P/169/21/L

Neal's Farmhouse West Wing, Lower Bognor Road, Lagness, PO20 1LW

Listed building consent for 11 No proposed windows replacement.

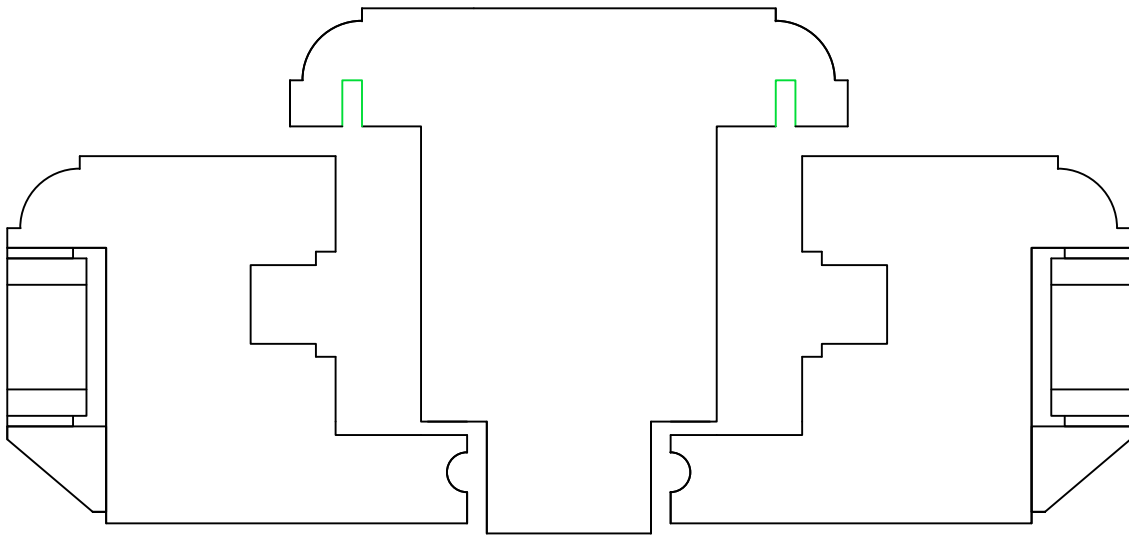
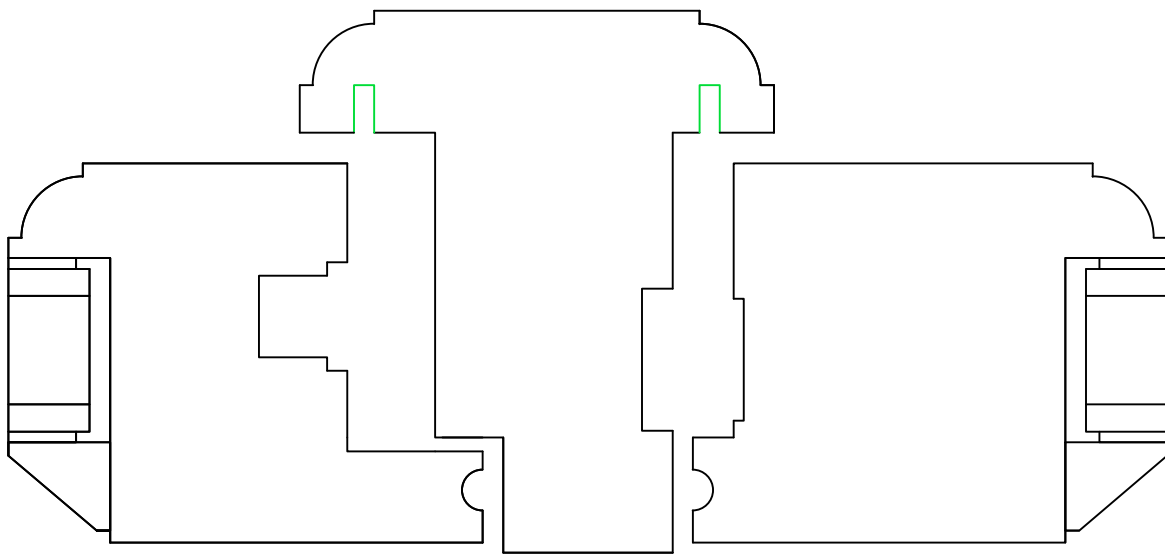
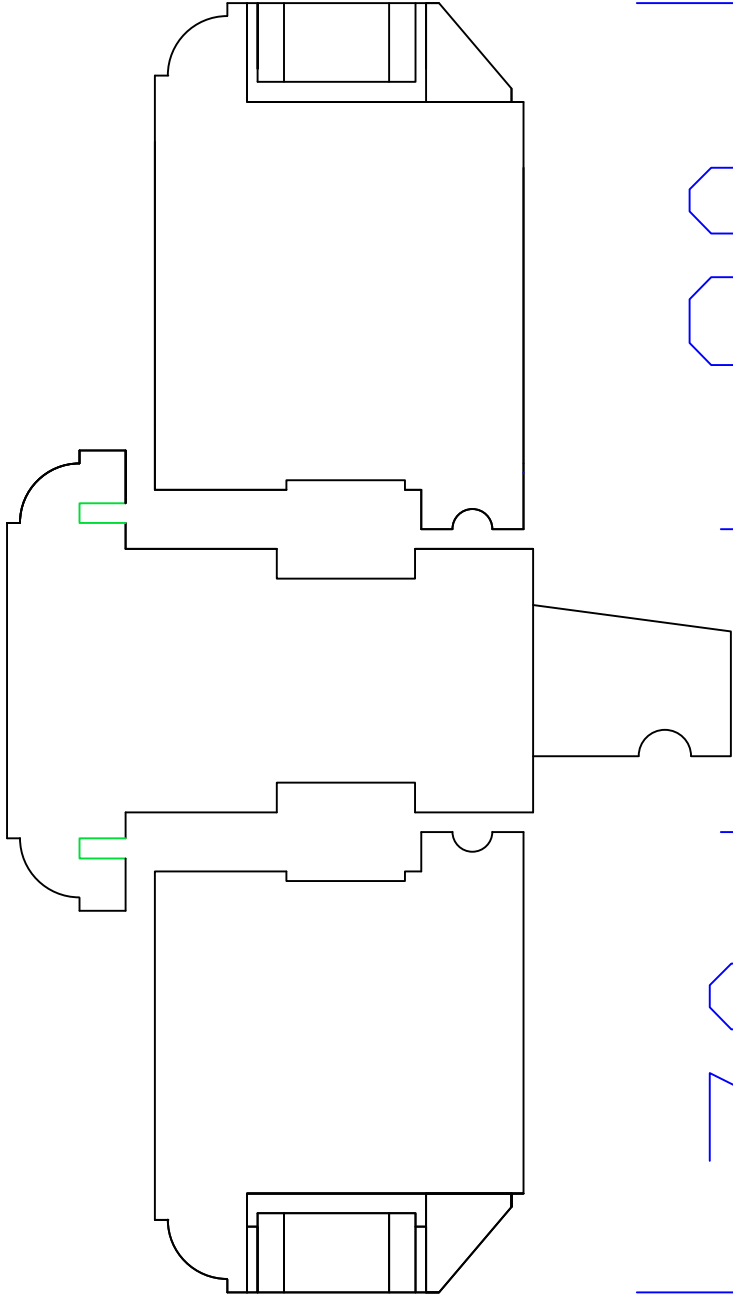
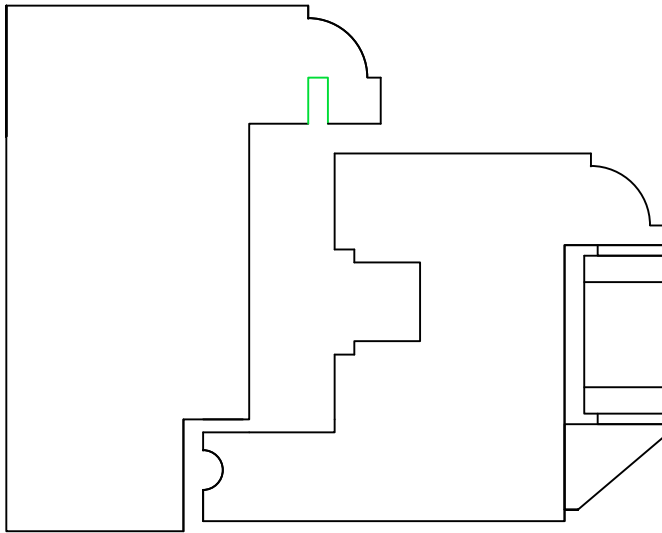
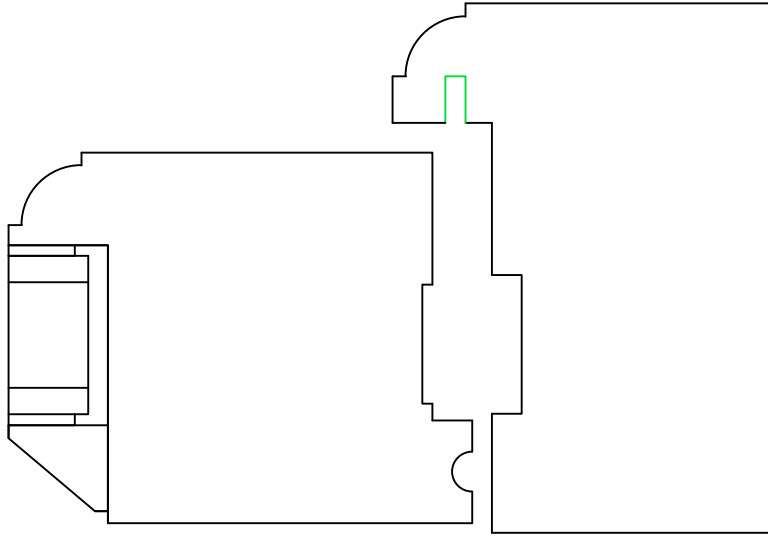
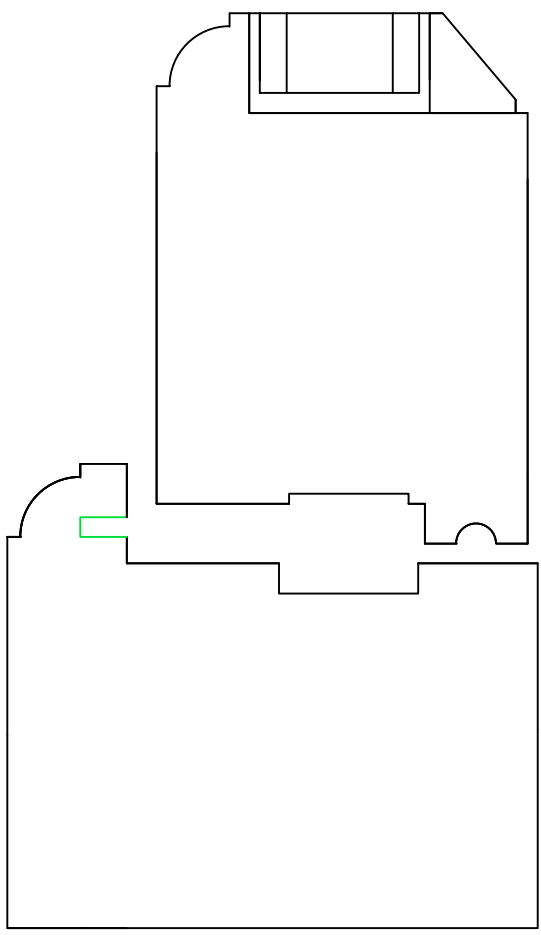
The replacement windows incorporate the slimmer double-glazed units (14mm thick) which is potentially acceptable in this instance as reference is made to the age of the windows in the heritage statement. However, there are still problems with the design of these windows in that the glazing bars are to be applied externally, as opposed to integral to the frame.

Traditionally, where windows have glazing bars, these form part of the structure of the window. False glazing bars applied to the surface of the window (with prominent spacer bars) are historically incorrect, aesthetically unconvincing, and can appear incongruous in the context of an old listed building such as this. Applied glazing bars also have a tendency to fail and leave the larger pane of glass visible. This is disappointing and harmful to the character of the windows/asset.

To achieve an authentic appearance, glazing bars in such windows should be integral and not glued to the face of the glass. It is also worth considering whether the spacer bars should be coloured the same as the joinery because the use of a contrasting colour draws attention to the fact that the window is double glazed. Further the method of holding the glazing using in place (with integral glazing bars) should be carefully considered i.e. putty or timber fillets.
